CITY OF ALBUQUERQUE

July 22, 2021

Re: Lizard Tail Brewery
9800 Montgomery Blvd NE, Ste 7
Traffic Circulation Layout
Architect's Stamp 06-17-2021 (G21-D007)

Based upon the information provided in your submittal received 07-21-2021, the above referenced plan cannot be approved for Building Permit until the following comments are addressed:

REVISED SITE PLAN

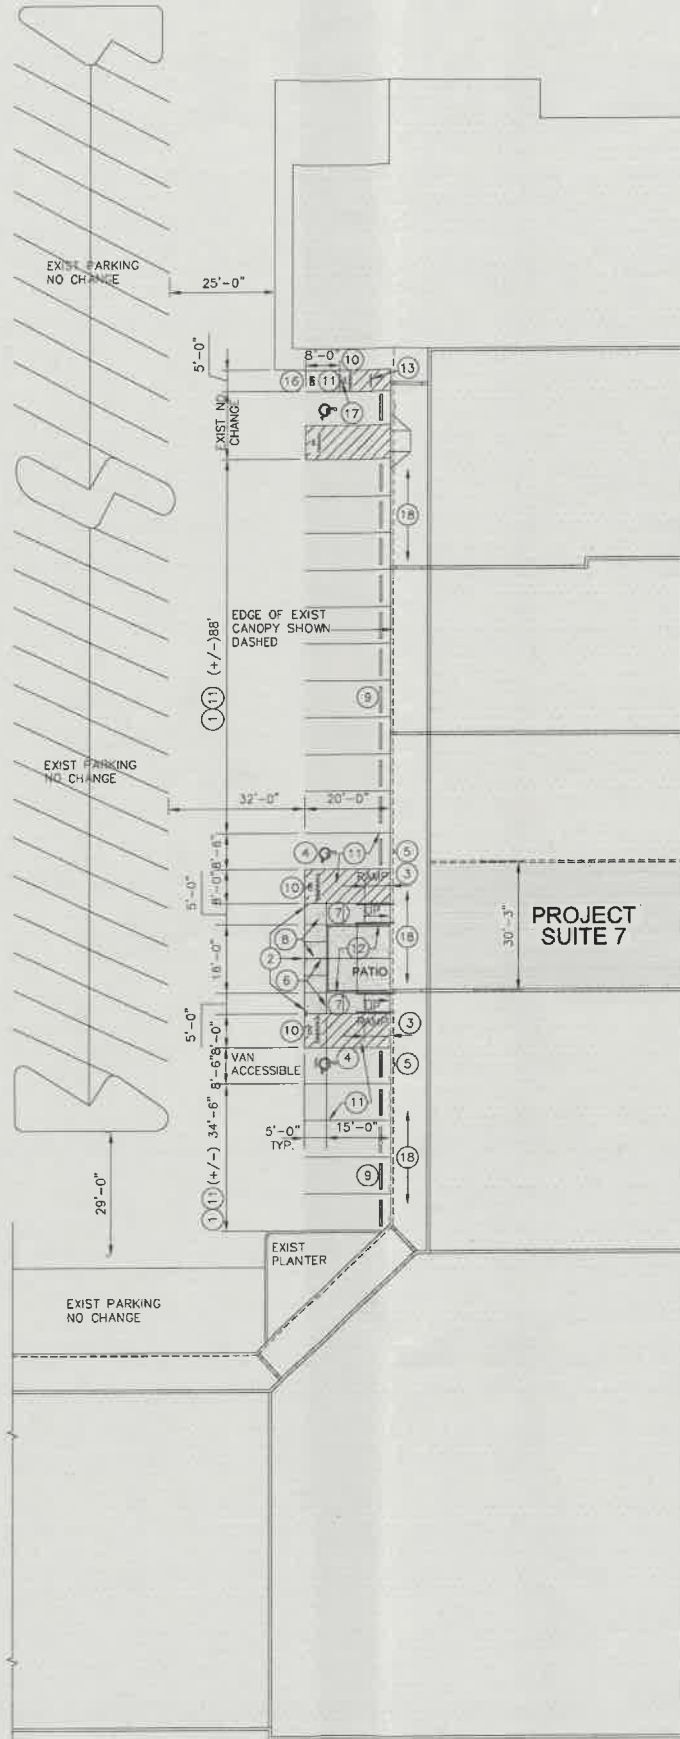
1. **Provide sidewalk width around the parameter of proposed Patio.**
2. **Site Plan parking ramp: Keyed Note 7 calls out 1:48 max for ramp but Detail 2 shows slope of 1:12 max. Please clear up or provide landing and ramp detail to separate the two grade changes.**

3. **Motorcycle parking spaces: Label pavement MC. What is the status for motorcycle parking spaces/ Explain. Please show the location of the motorcycle parking stall.**

4. **Show all drive aisle width.**
5. **Provide a copy of the receipt for resubmittal fee.**
6. **Shared Site acces: Provide a copy of 'Cross Easement Access Agreement' needs to be provided. Not provided in attachment.**

7. **Add a note stating "All broken or cracked sidewalk must be replaced with sidewalk and curb & gutter." A build note must be provided referring to the appropriate City Standard drawing. Reference COA std dwg 2415 instead of 2450.**
